# ***City of Albuquerque***

March 5, 2004

**Re: Southwest Hobbies, 3400 Menaul Blvd. NE, Traffic Circulation Layout  
Architect's Stamp dated 2-26-04 (H16/D16)**

TRAFFIC CONTROL LAYOUT

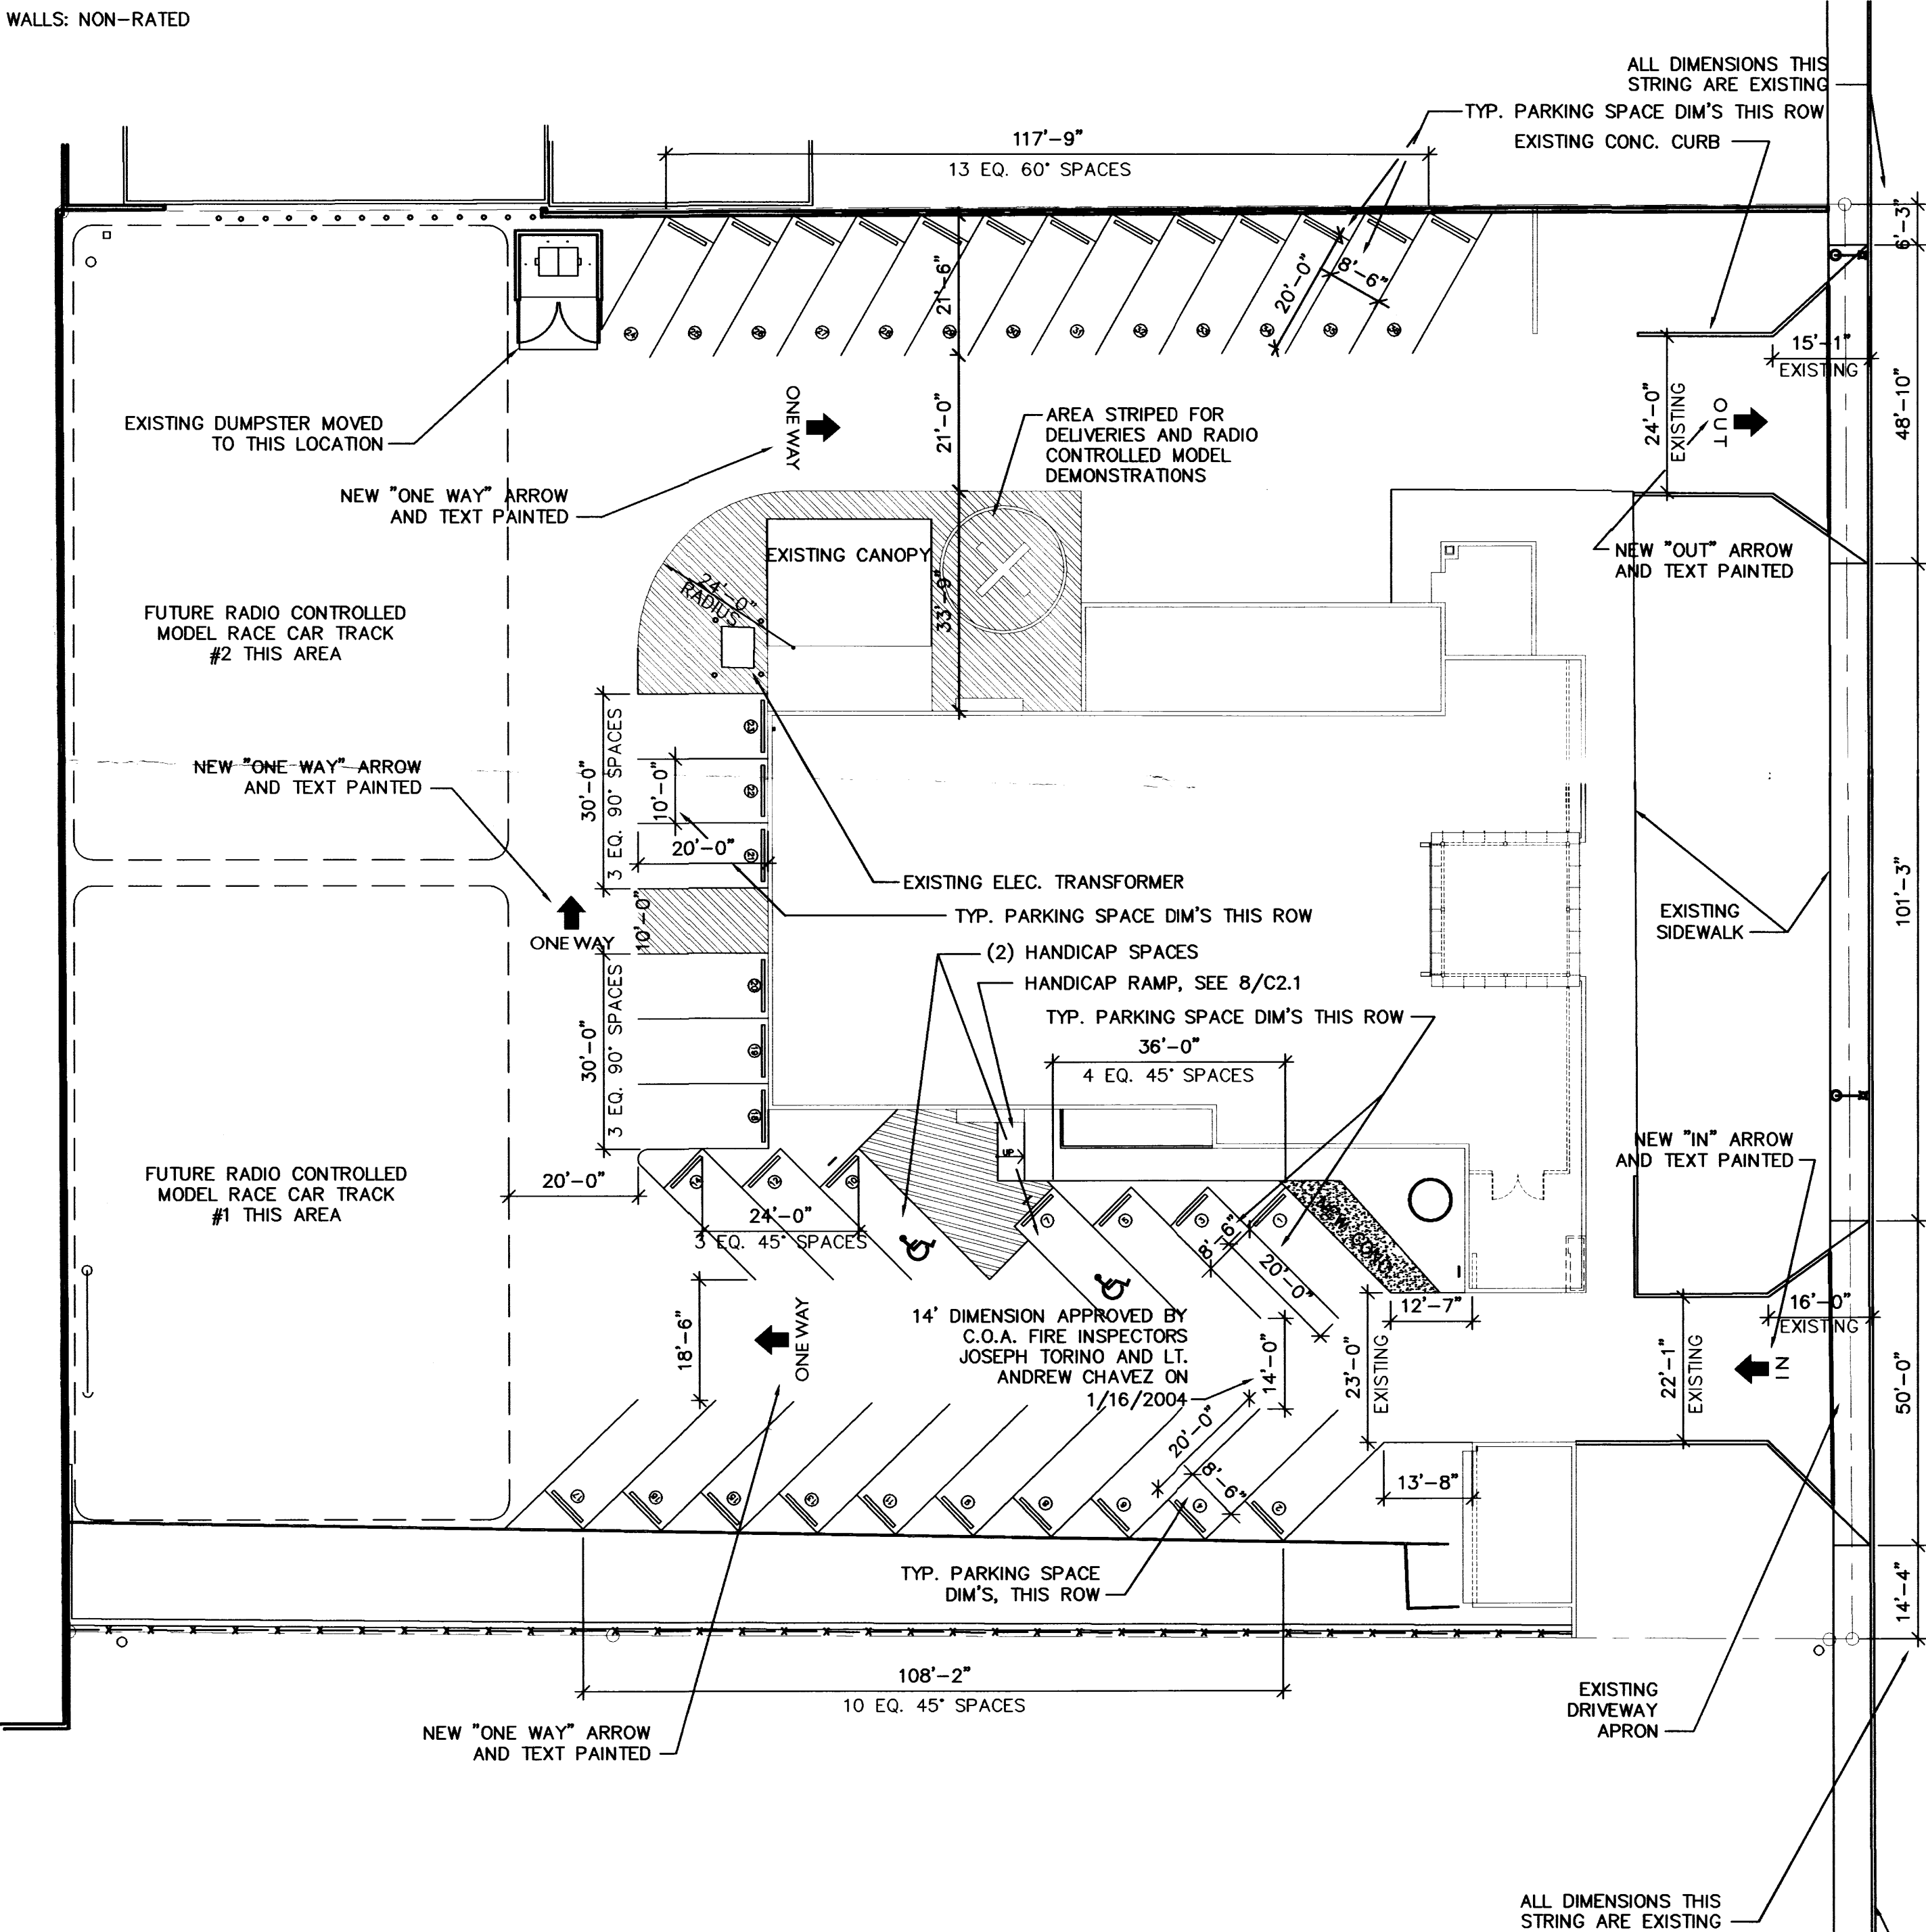
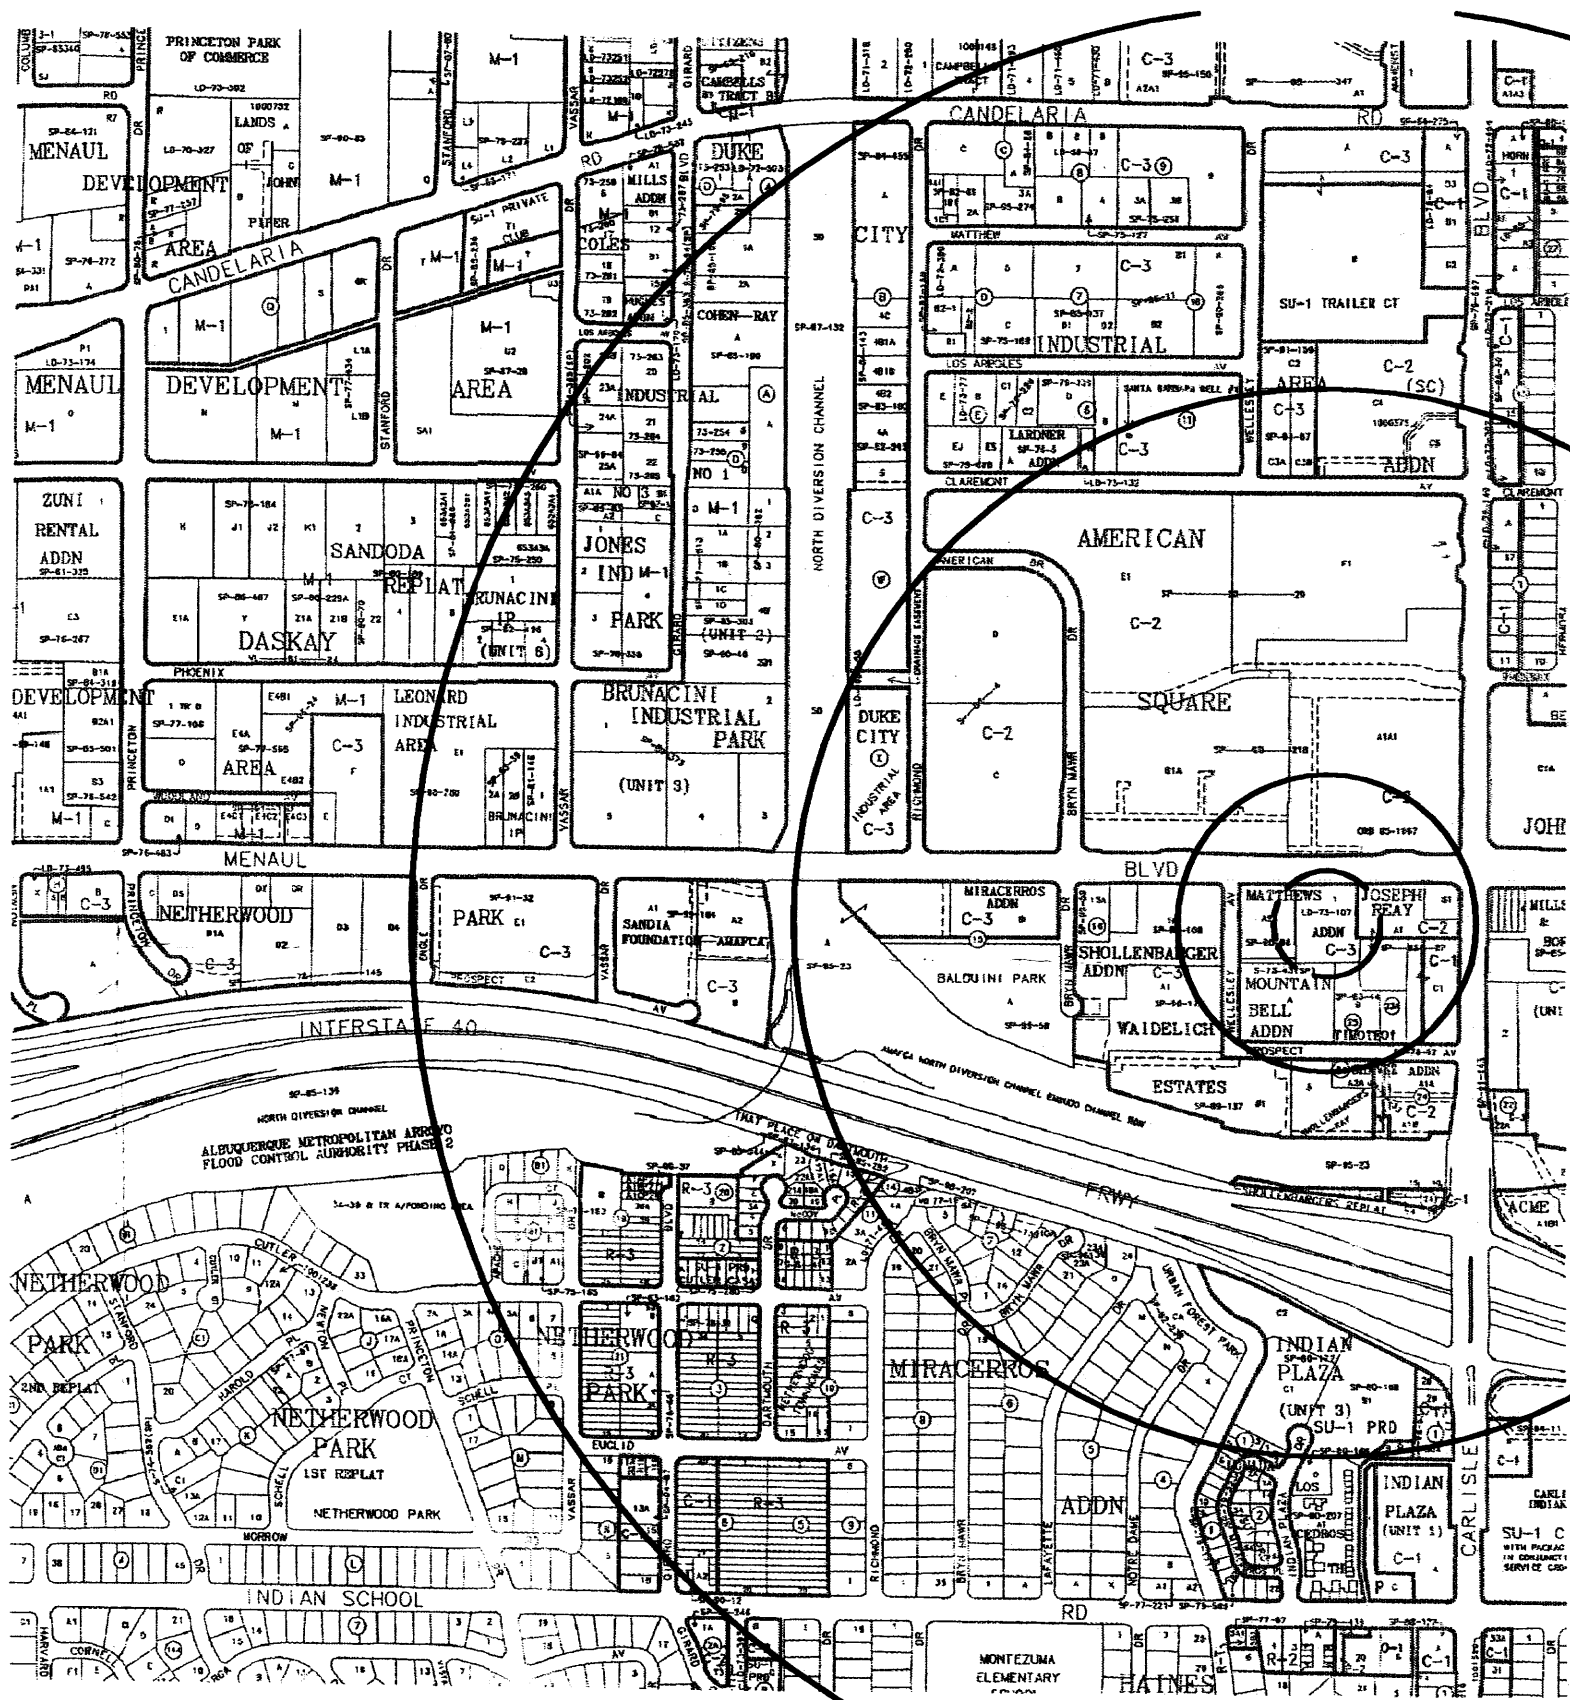
1. Please list the width of the existing and proposed sidewalks.
2. The handicapped space, called out as space number 7, does not provide sufficient protection for exiting drivers. Please relocate this space.
